Recommendation Report for Planning Permission for Works or Extension to a Dwelling

REF NO: M/109/19/HH

LOCATION: 23 Southdean Drive
Middleton-On-Sea
PO22 7TA

PROPOSAL: Proposed single storey front extension and alterations

1207-01

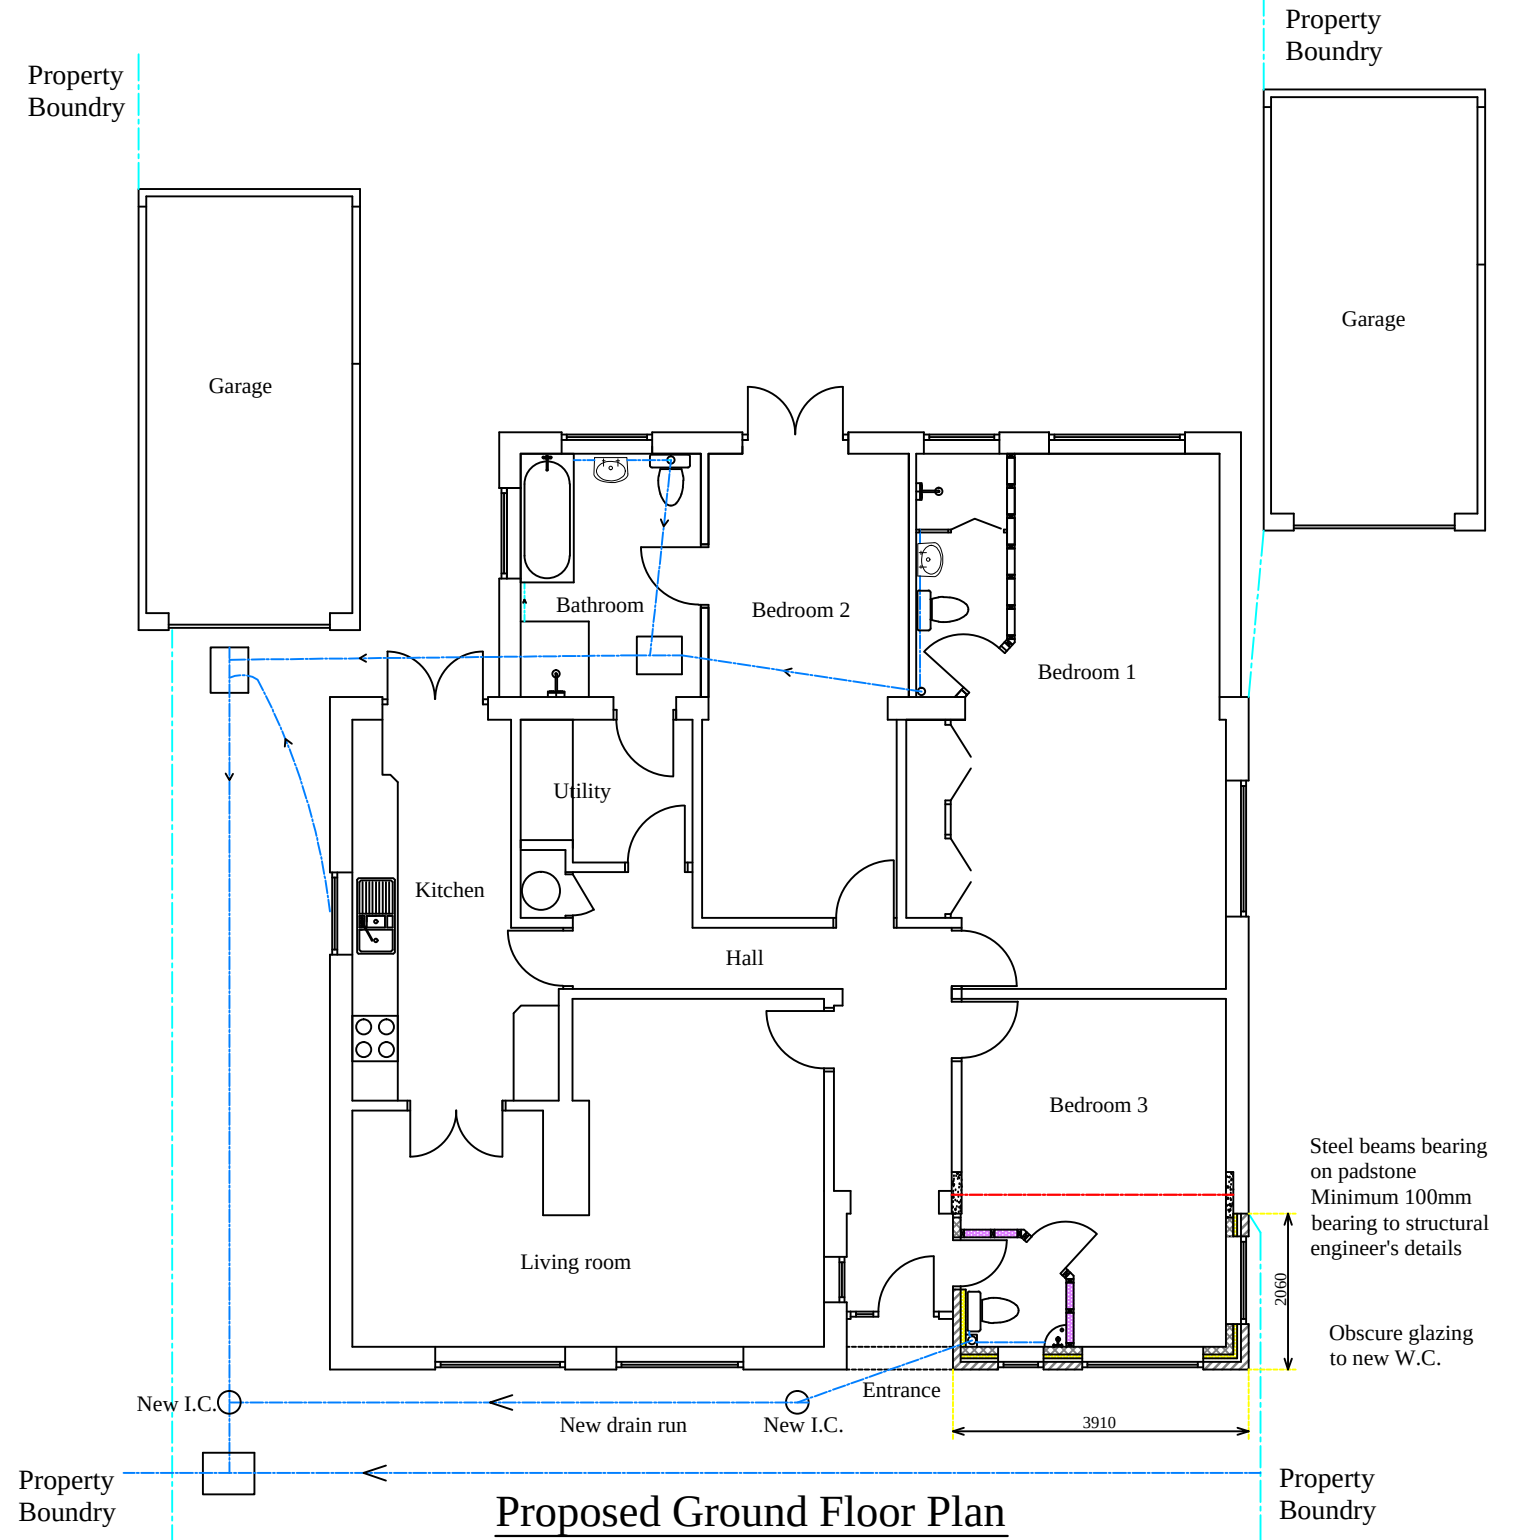
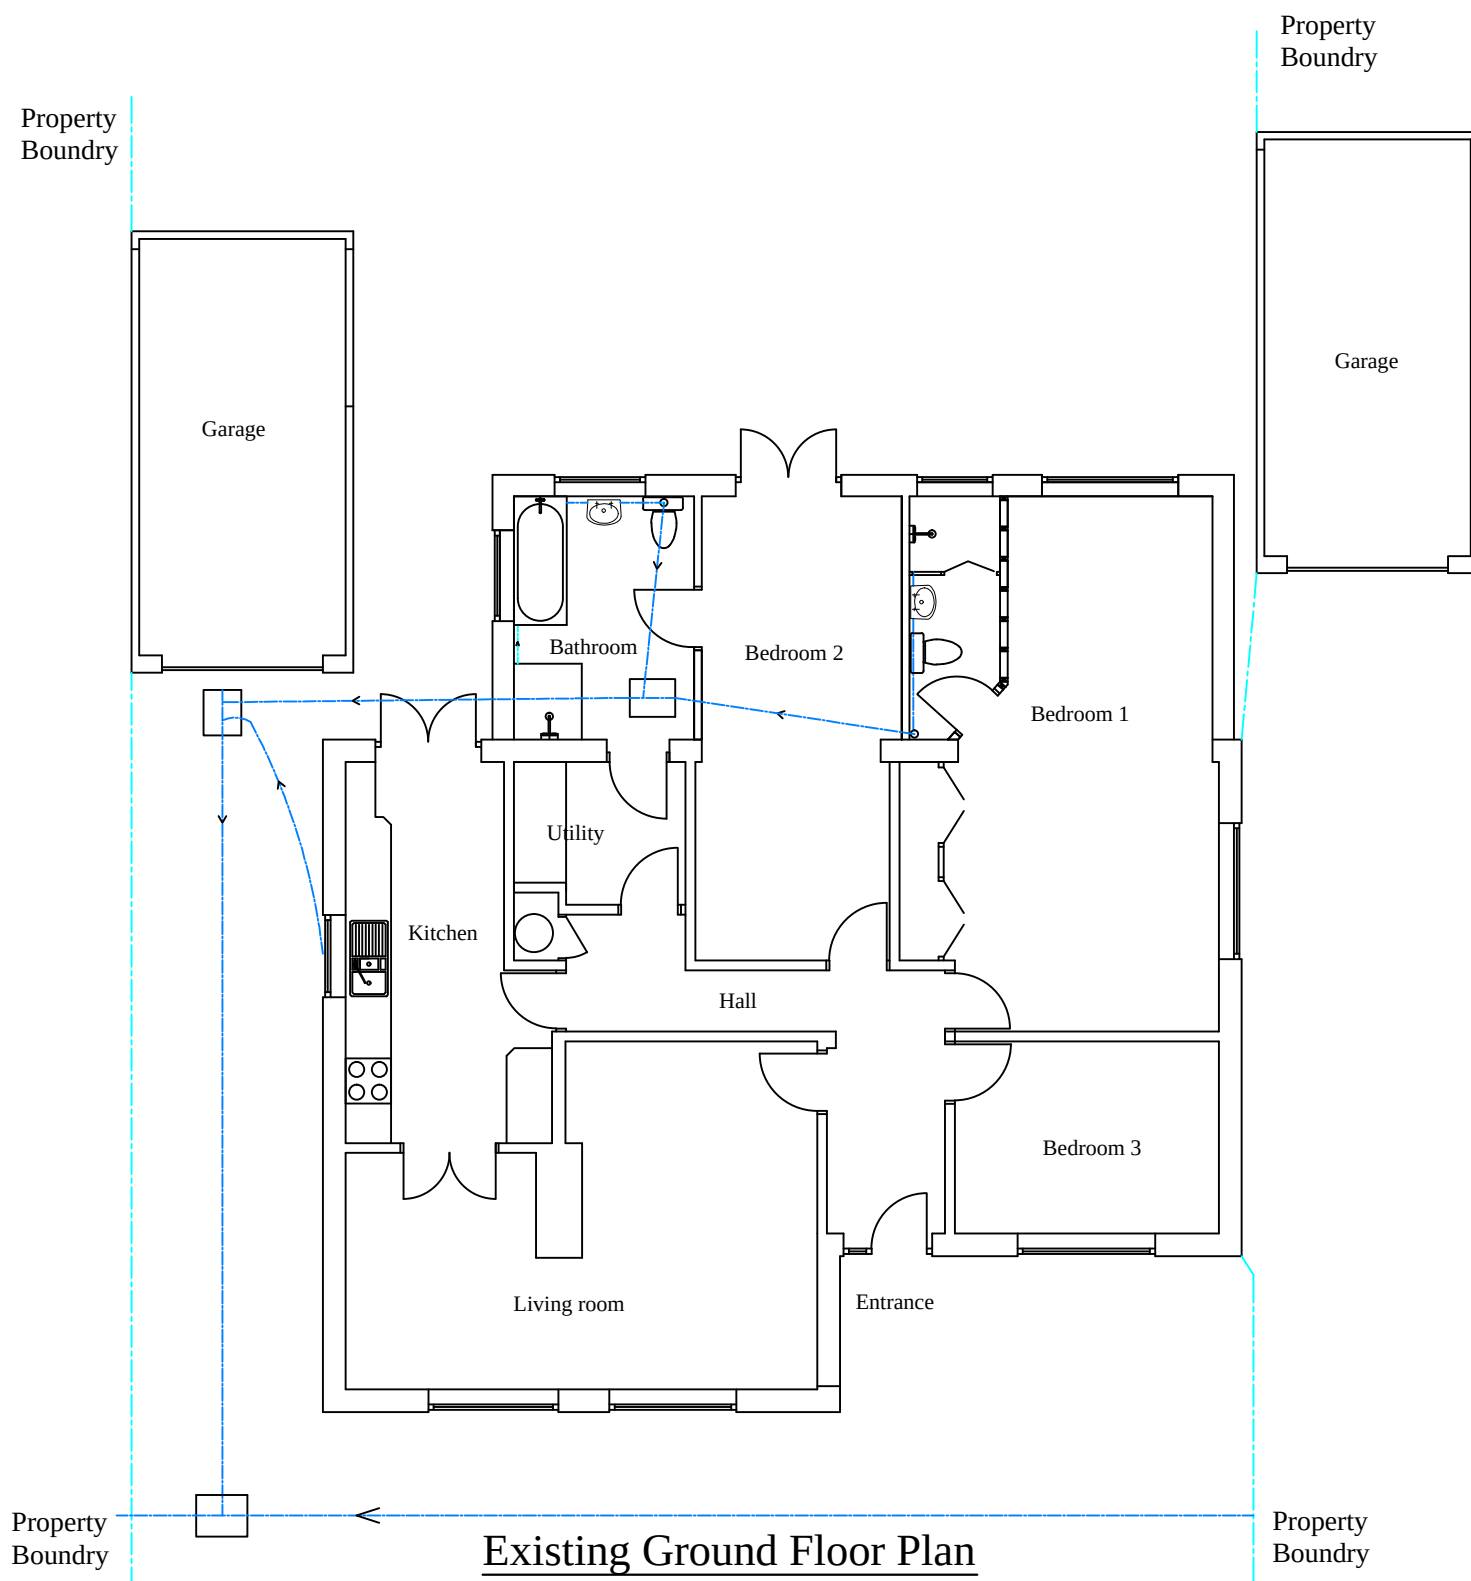
Due to its siting, the proposed development will be visible from the street scene. The measurements of the proposed front extension is 3.9m in length and 2m in width. There would a new window placed on the southern wall of the extension, this will be 1.8m in height. The change in appearance of the host dwelling is not considered to give rise to any significantly harmful impact upon the character of the host dwelling, or its locality. This is due to its design, modest scale, and proposed materials, which will be identical to the main dwelling, allowing the extension to appear sympathetic to, and well integrated into the local area. Its size is also subservient to the host dwelling.

PROJECT	Proposed single storey Front extension & alterations 23 Southdean Dive, Middleton-On-Sea, PO227TA		
TITLE	Proposed elevations		
CLIENT	Mr & Mrs Keith Jordan		
SCALE	1: 100	DATE	18/12/2019
DRAWING NO.	1207-03	rev.

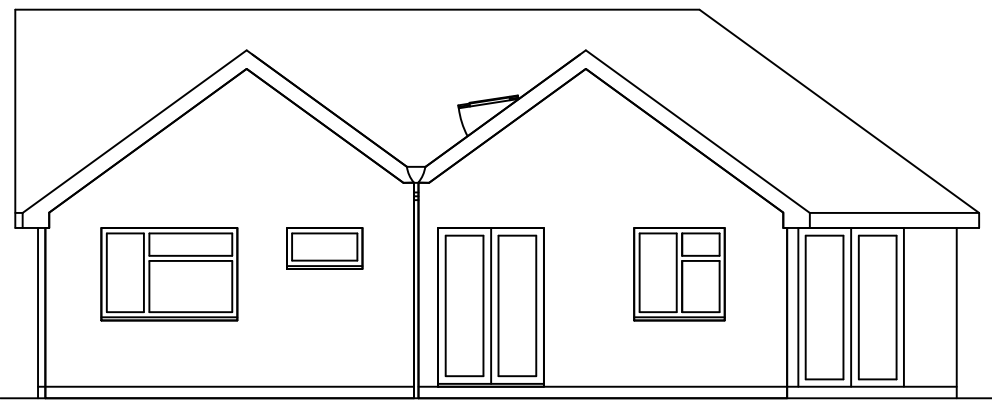
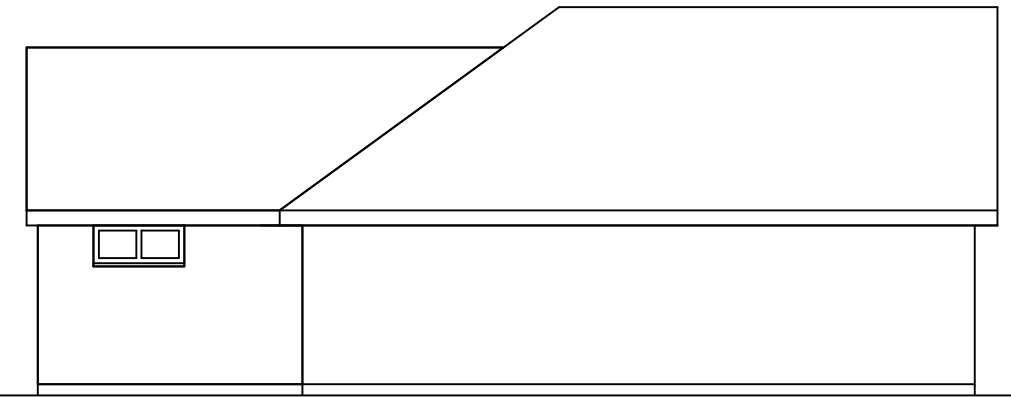
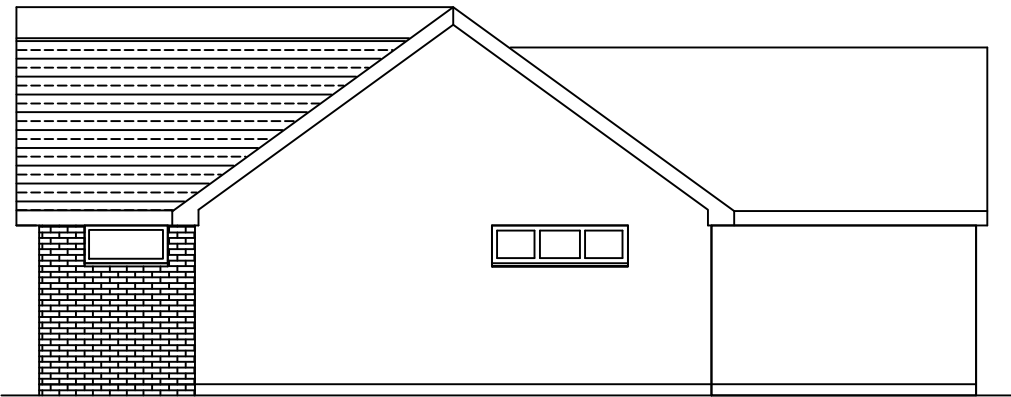
The proposed development is not considered to give rise to any significantly harmful impact upon the residential amenities of neighbouring dwellings. Due to the size and design of the extension it will not cause any overbearing or over shadowing to the surrounding properties. There will also not be a loss of privacy of neighbouring properties from overlooking due to the acceptable height of the new southern window.
